Recommendation Report for Planning Permission

REF NO:	WA/50/22/PL
LOCATION:	Oak Bank Wandleys Lane Walberton BN18 0QR
PROPOSAL:	1 No 4 bed dwelling with detached garage and associated parking (resubmission following WA/8/22/PL). This application is a Departure from the Development Plan and is in CIL Zone 3 and is CIL Liable as a new dwelling.

Site Block Plan 1:200

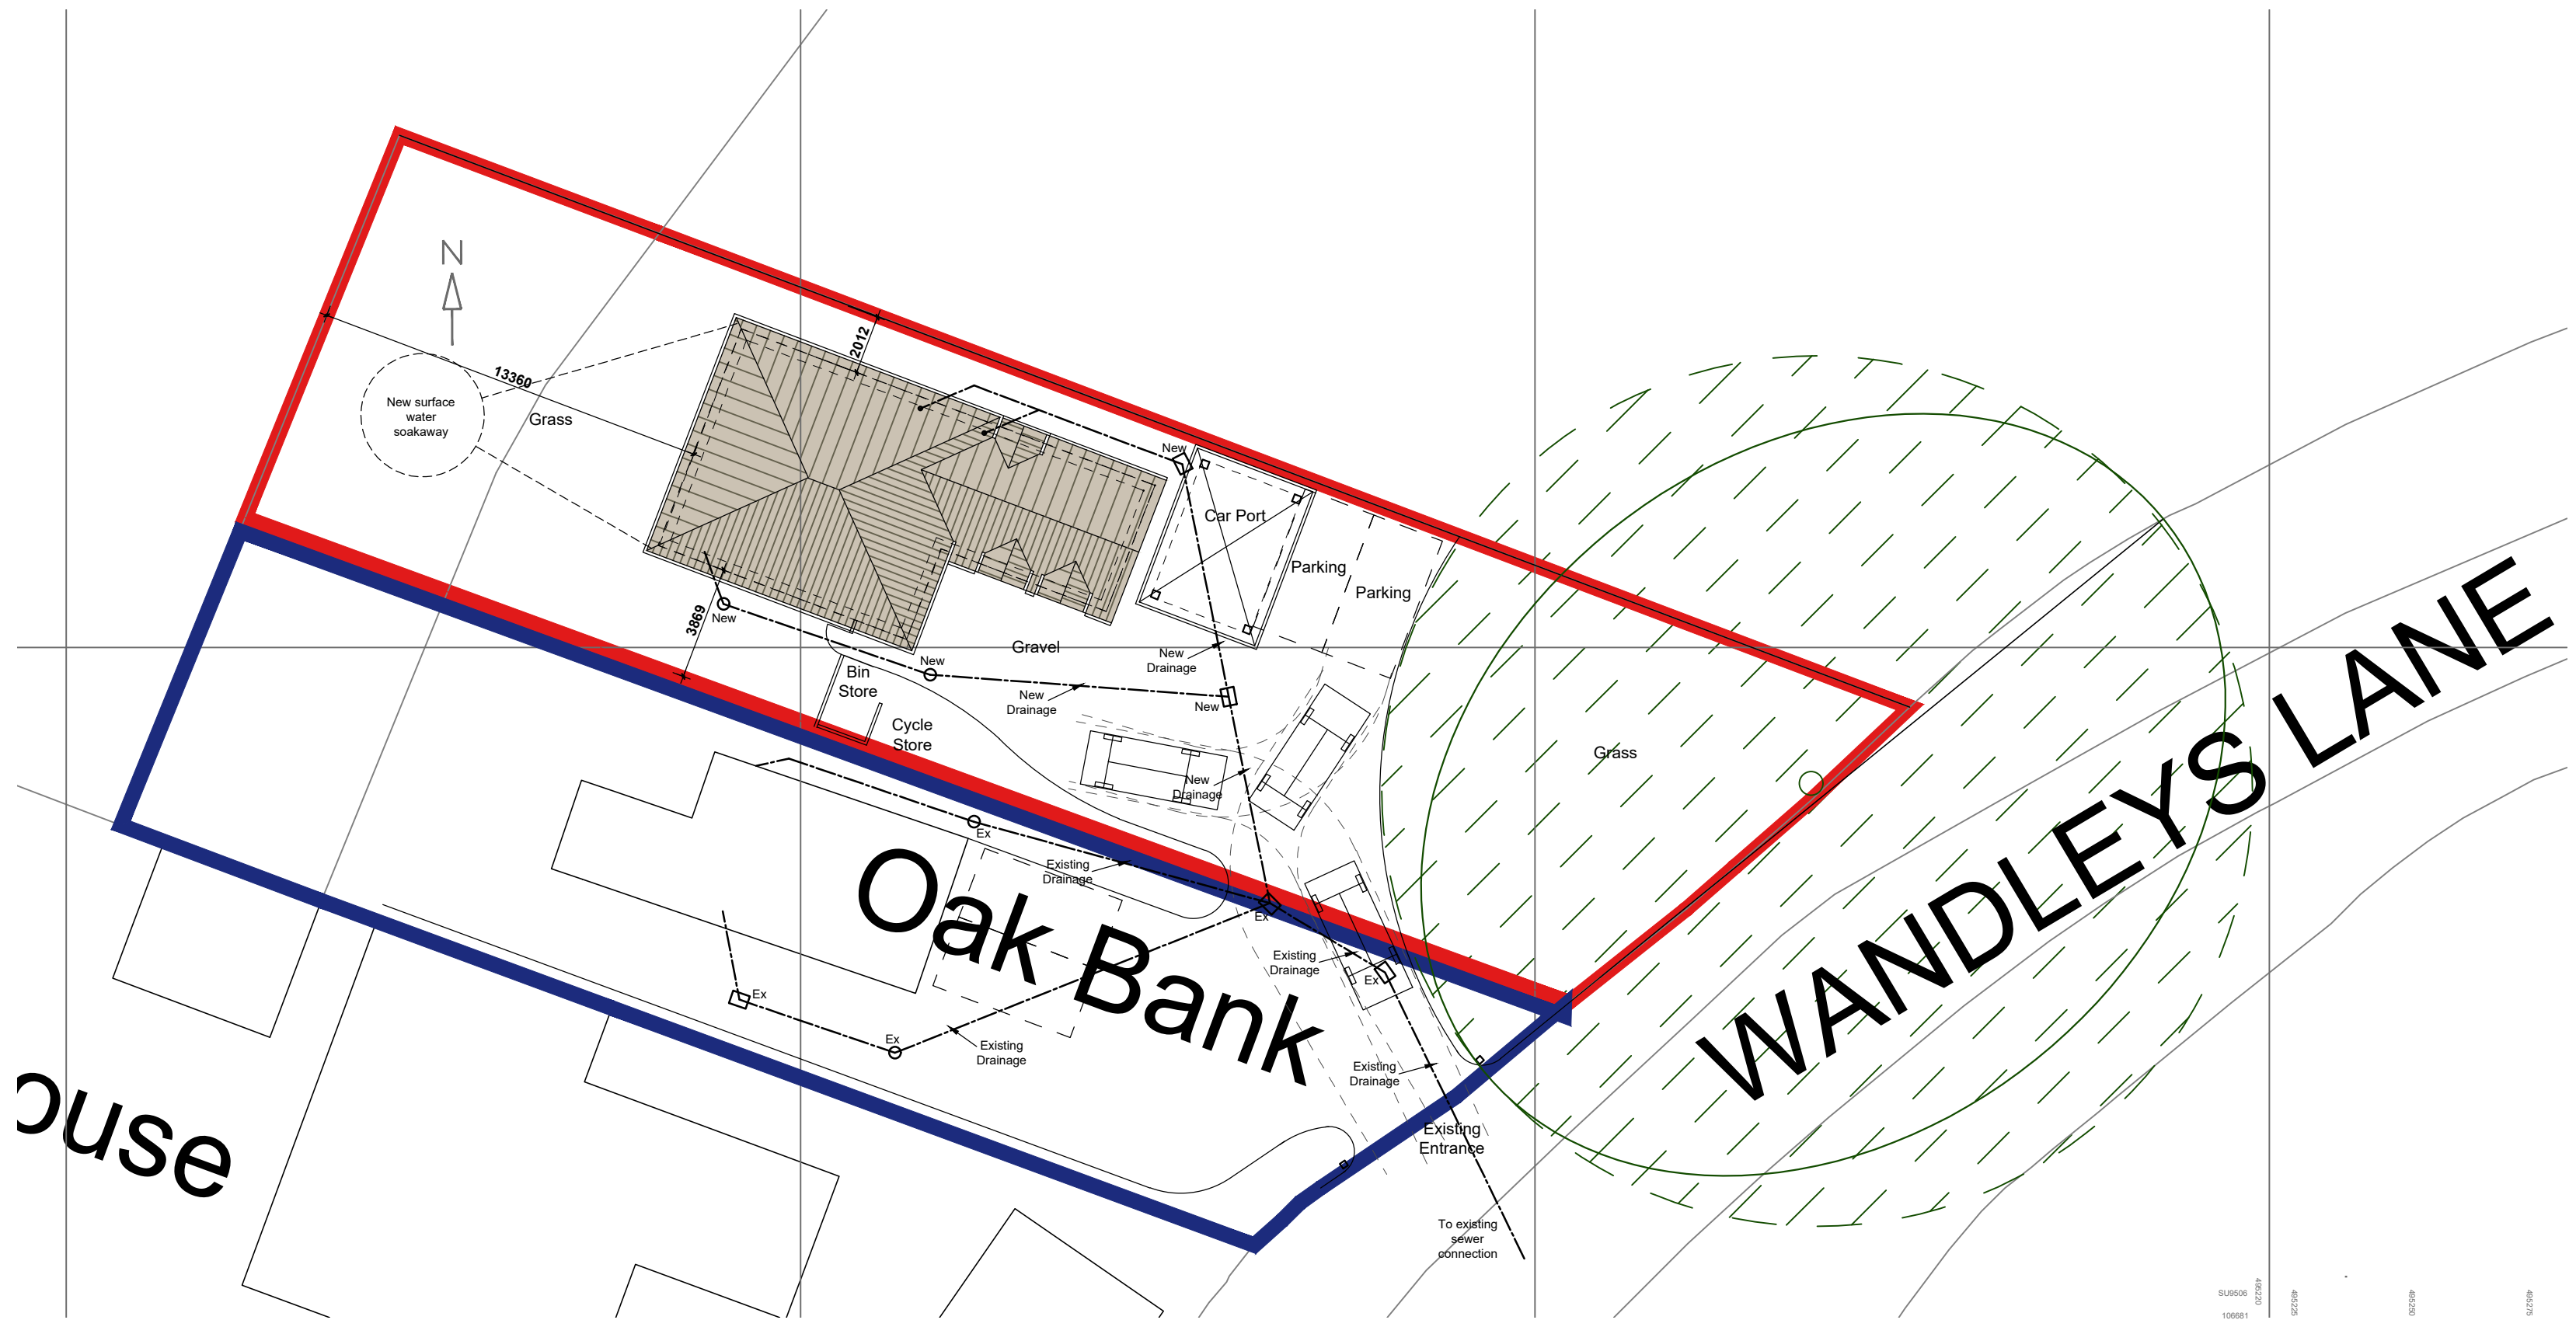
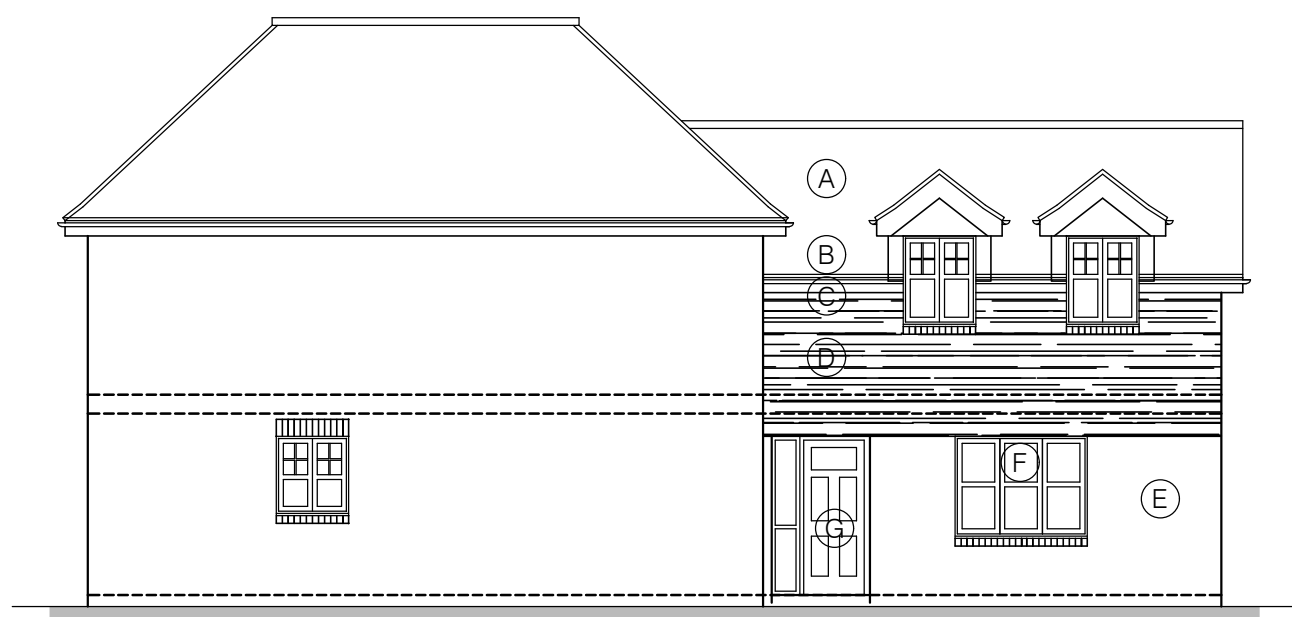
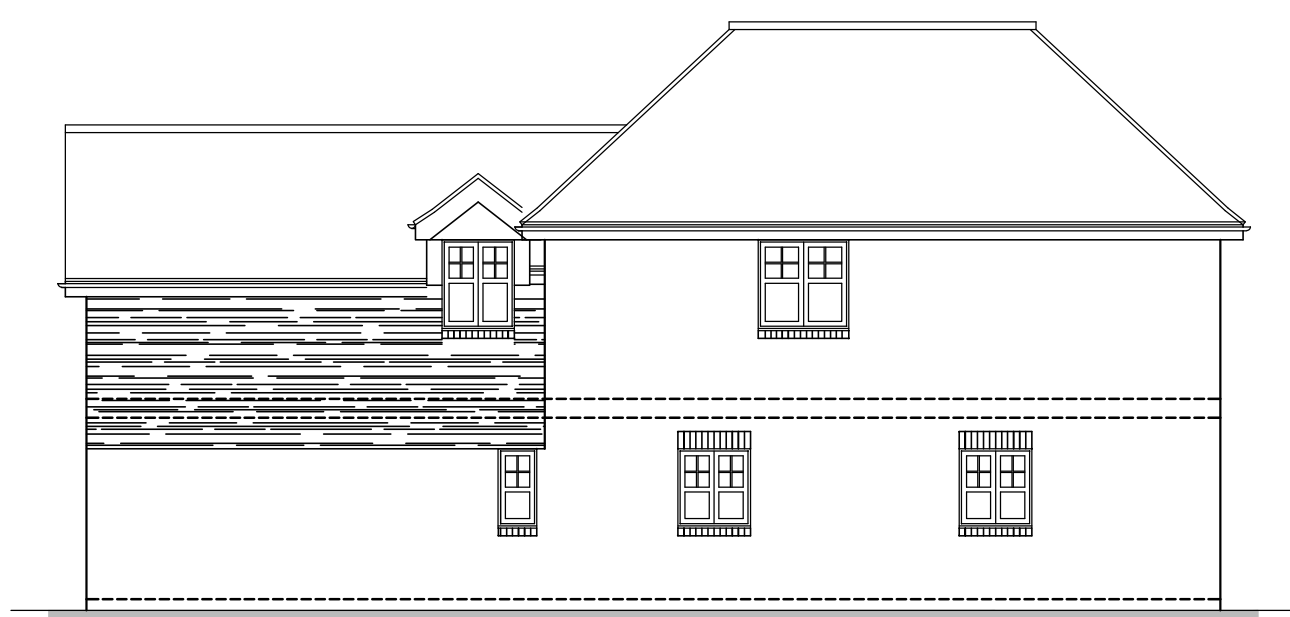
The house would be significantly larger than Oak Bank; 15 m deep and 7.9m wide, the main building would be characterised by a hipped roof (the roof of Site Block Plan does not match with the roof shown on elevations) its front 2-storey projection would have gabled roof with one dormer facing to the north-east and 2 dormers to the south-west. A single car port is proposed to the front with a separation distance of 0.5m from the front elevation of front along with 2 parking bays.

The above report and plan were specific to the preceding application but do not comprehensively associate with the current proposal (block plan) shown on drawing no. 21034/001P Rev F. T1 is a tree of such importance (high amenity/landscape value, potential heritage tree) and sensitivity (mature, growing in increasingly hostile surroundings) that it should represent a major constraint to development. It is therefore pleasing to see no major construction proposed within the root protection area (RPA) and crown spread, although sensitive working would be required to ensure no overspill into a Construction Exclusion Zone.
